June 27, 2024

**SUBJECT: WDFW COMMENTS ON SE-24-00020 MAJESTIC GROUP SEPA**

Thank you for the opportunity to comment on the Majestic Group LLC's proposed project on parcel 778834, near Lake Easton and Interstate 90's Exit 70. The Washington Department of Fish and Wildlife (WDFW) is familiar with the project area and we've reviewed the application materials available on file. The SEPA checklist and Notice of Application mention the need for a Forest Practice Application (FPA) as well as grading and fill associated with an access road, but there are no site plans or specific information available to evaluate the project for environmental impacts.

Critical Areas

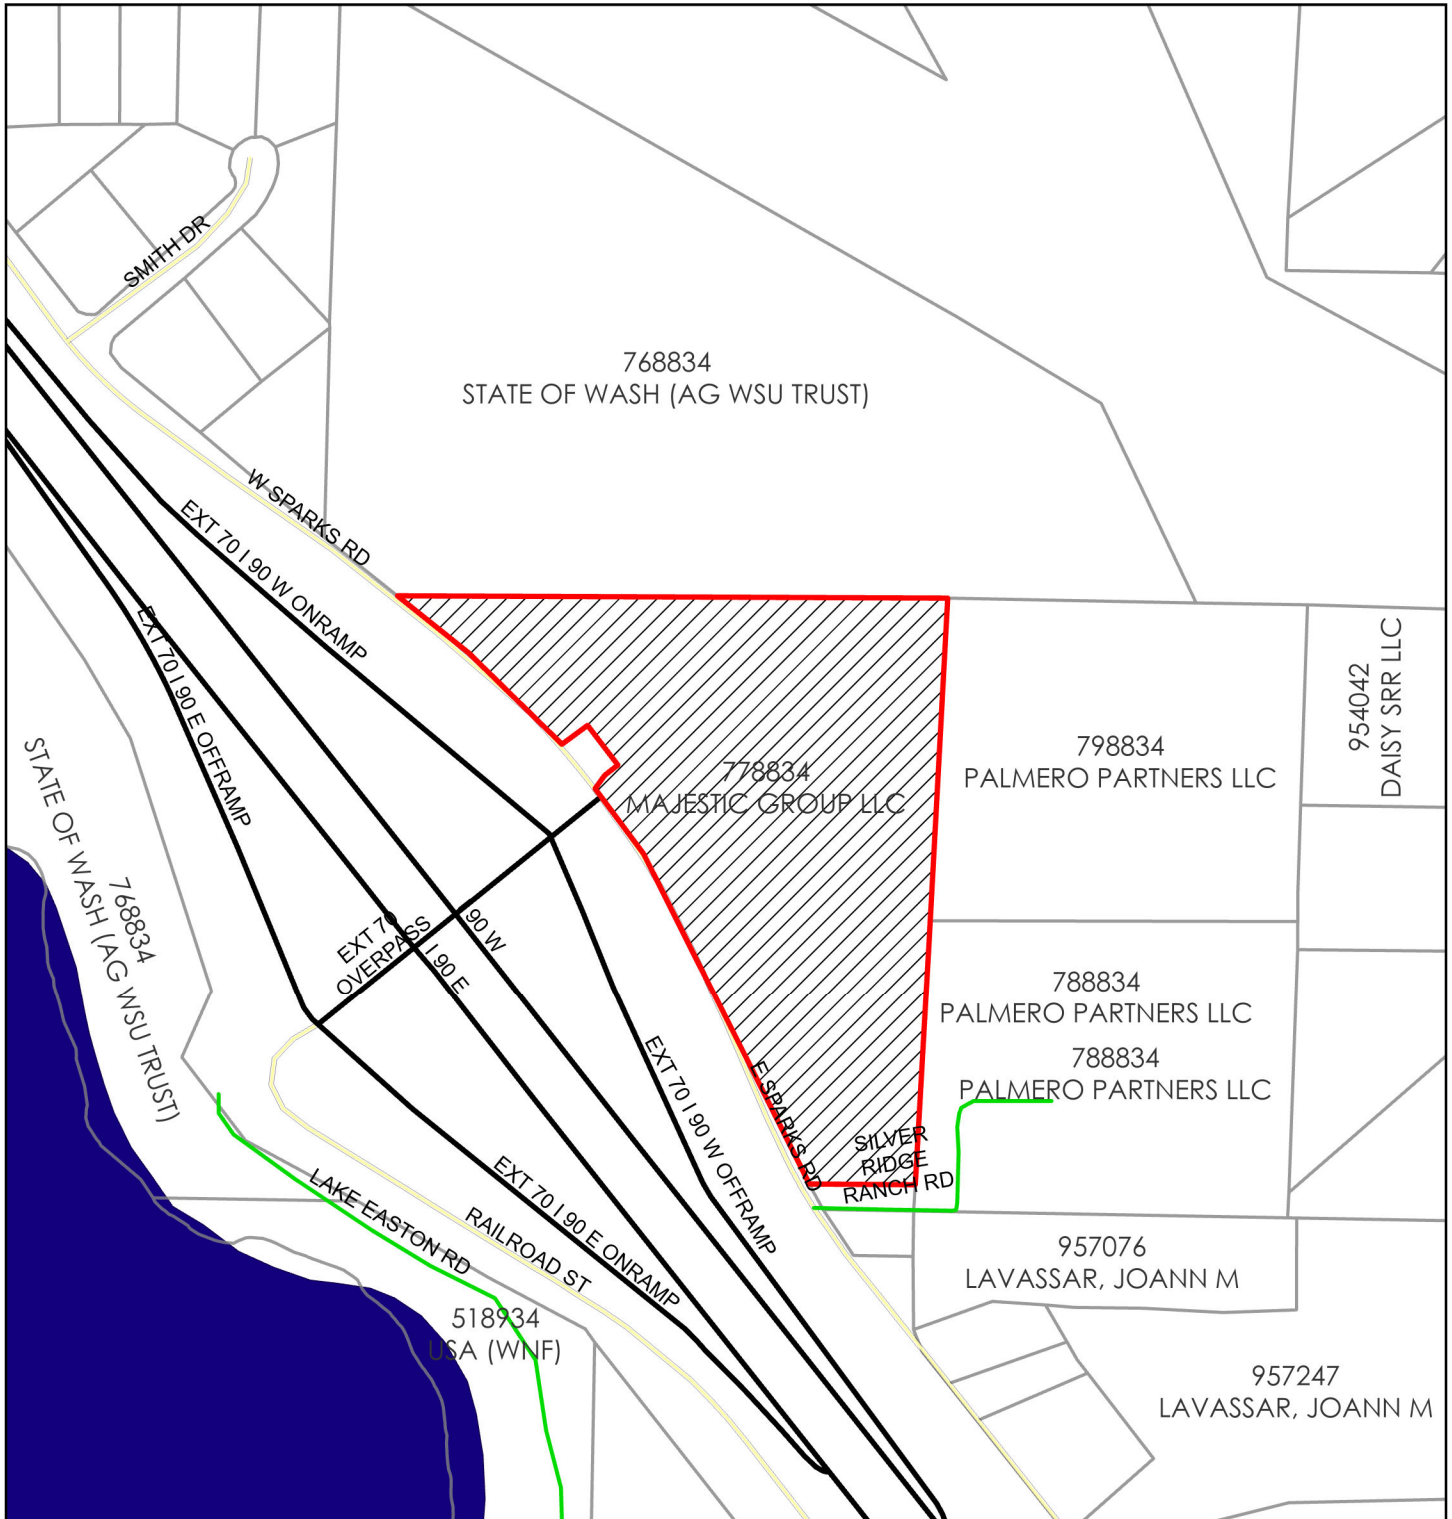
- Complete a critical areas study to evaluate the property for all critical areas so they can be properly identified and protected or mitigated for per KCC 17A. WDFW's PHS online mapper clearly shows the project area is within designated Elk Winter Range, a Fish and Wildlife Habitat Conservation Area. Clearing nearly the entire lot may negatively impact elk and other wildlife present on or near the site, which requires mitigation per KCC 17A.01.100. Any future developments are also likely to have impacts to elk winter range.
- The project site is near the easternmost I-90 Connectivity Emphasis Area (CEA) identified to enhance ecological connectivity as part of the WSDOT I-90 East Project. Understanding the proposed project as a whole will be important for evaluating how it may impact wildlife connectivity through this CEA and the ability for wildlife to migrate through the area.
